# CITY OF ALBUQUERQUE

RE: **Lot 10 Block 4 Unit 18 SAD 228**  
**Volcano Cliffs Subdivision**  
**6611 Cuervo Pl. NW**  
**Grading and Drainage Plan**  
**Engineers Stamp Date 12/13/2021 (D10D003J10)**  
**CO Certification Date 12/12/2022**

Based on the Certification received 12/14/2022, this site cannot be accepted for release of Certificate of Occupancy by Hydrology until the following comments are addressed.

CANDELARIA HOMES (ADAN) - G & D PLAN

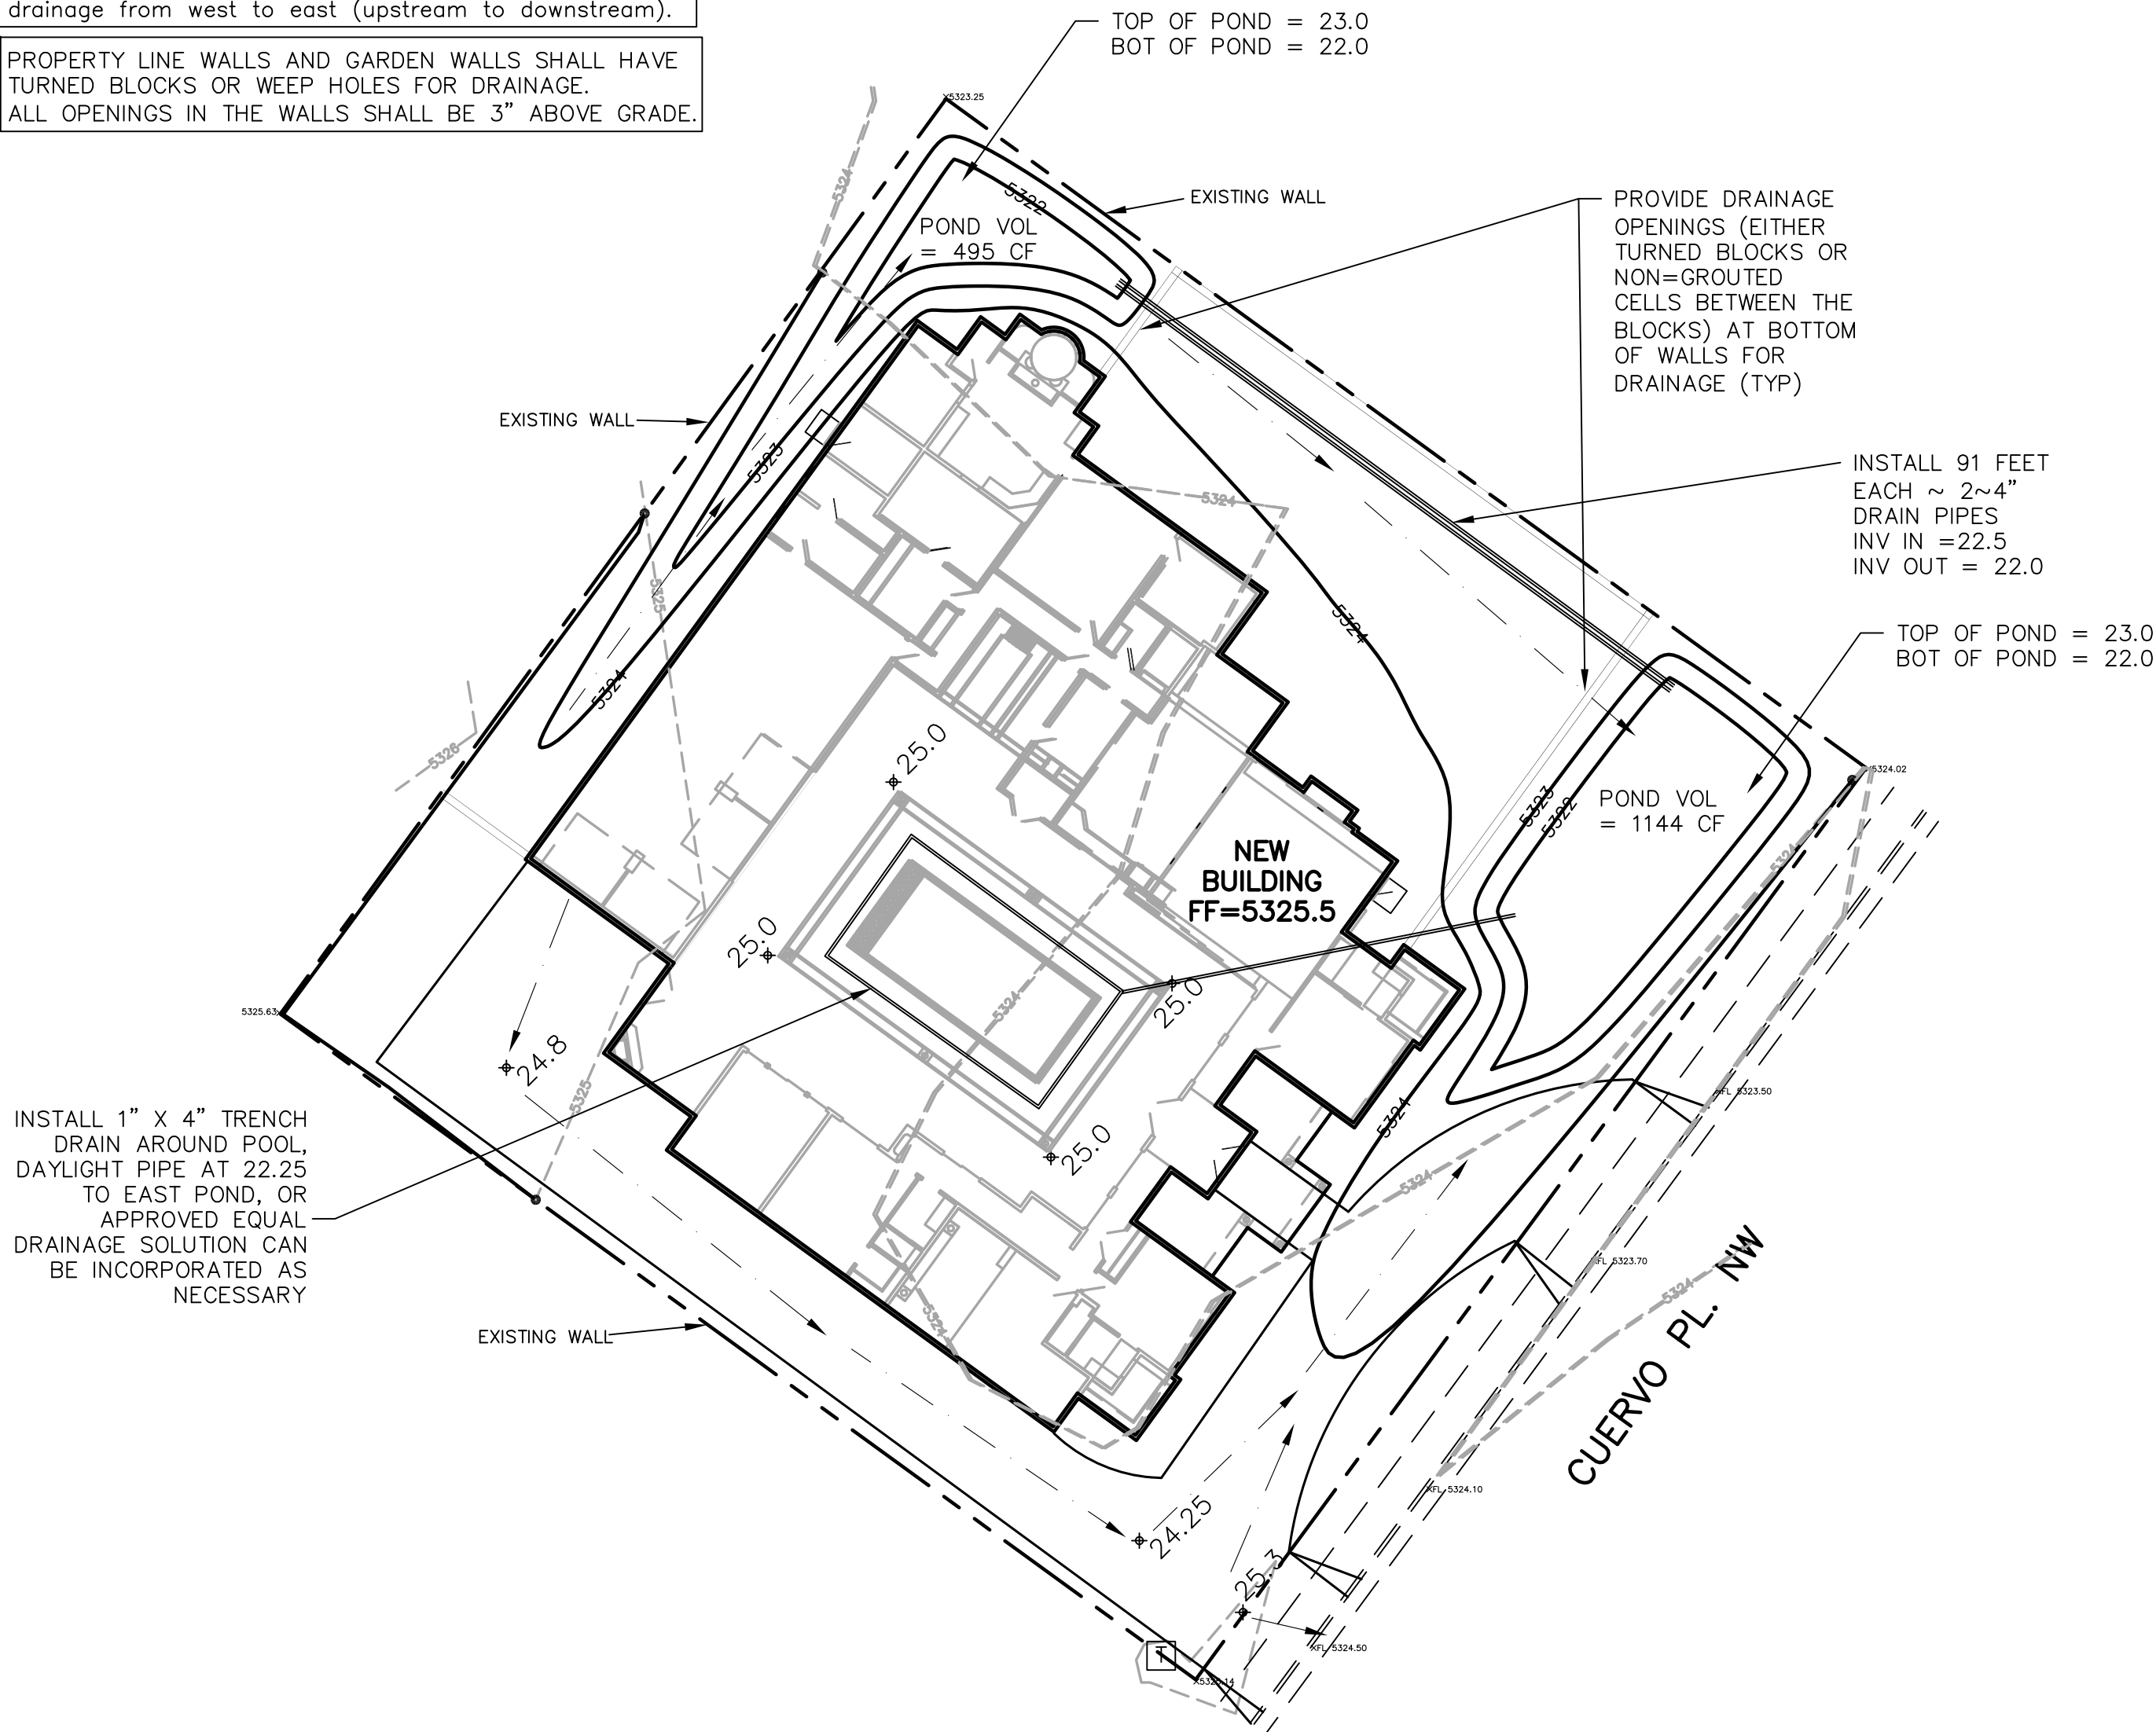
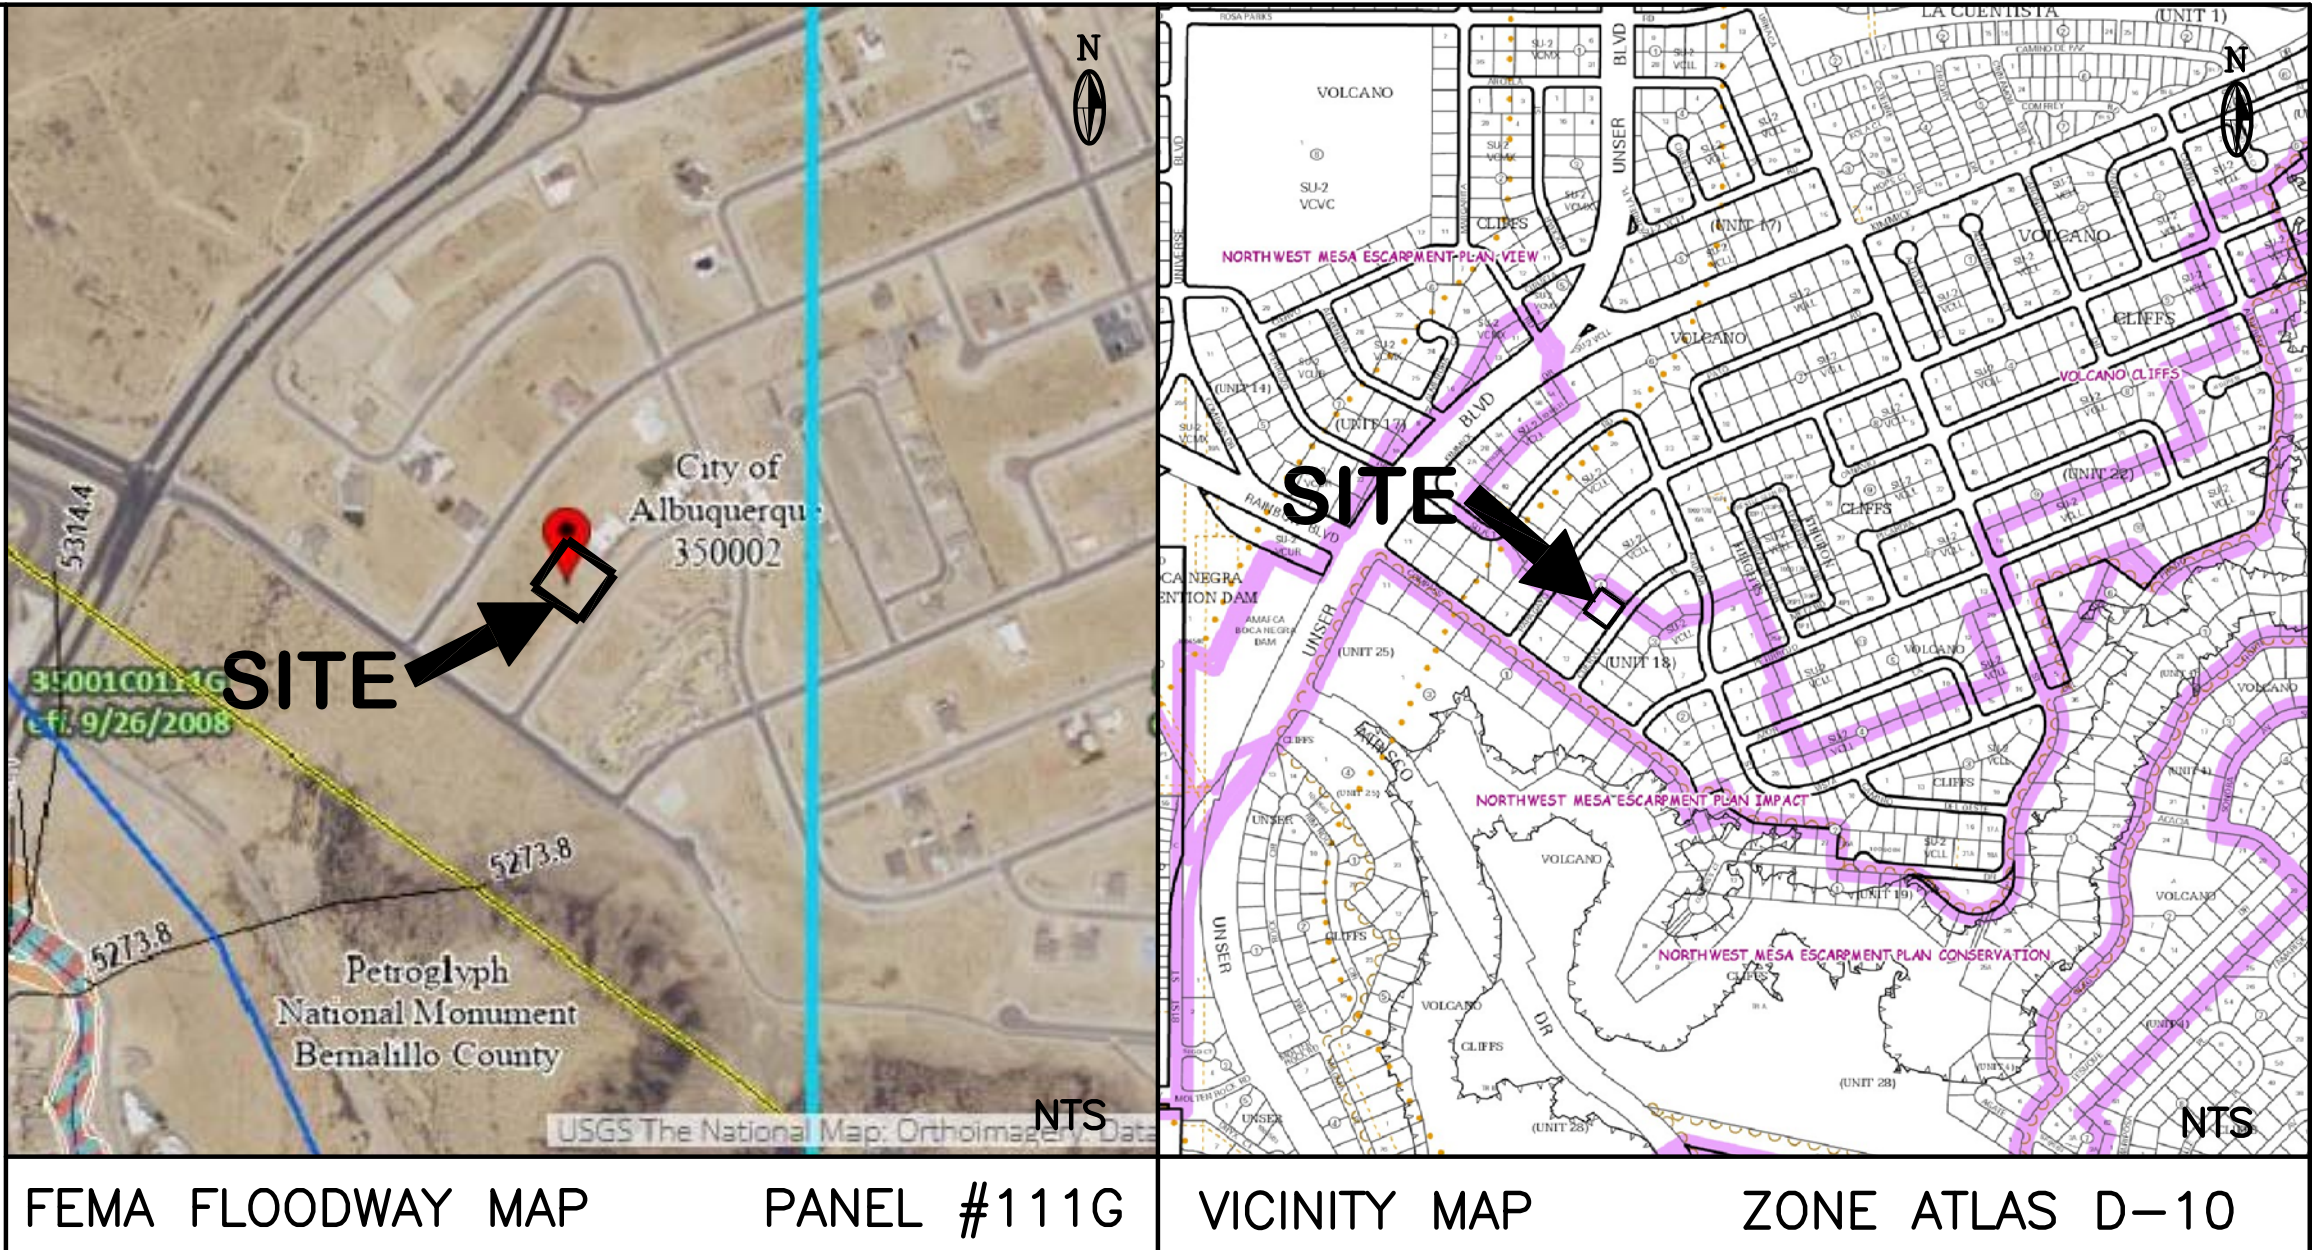
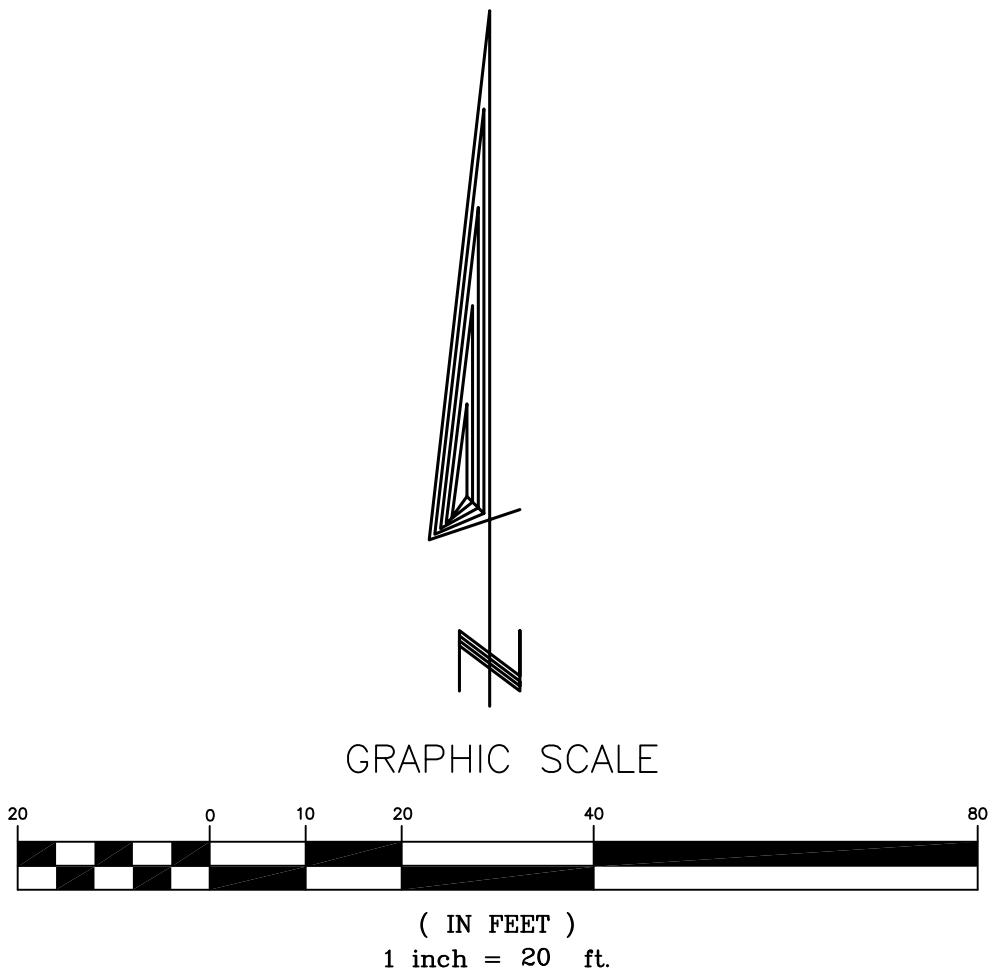
- Provide gravel in all ponds and swales.
- Provide a ponding area in the SW corner. Driveway blocks the flows heading to the NE corner.
- It is acceptable for flows to enter volcano cliffs property; however, there must be a sediment pond in place before these flows enter public land.
- Erosion protection is required at block fence.
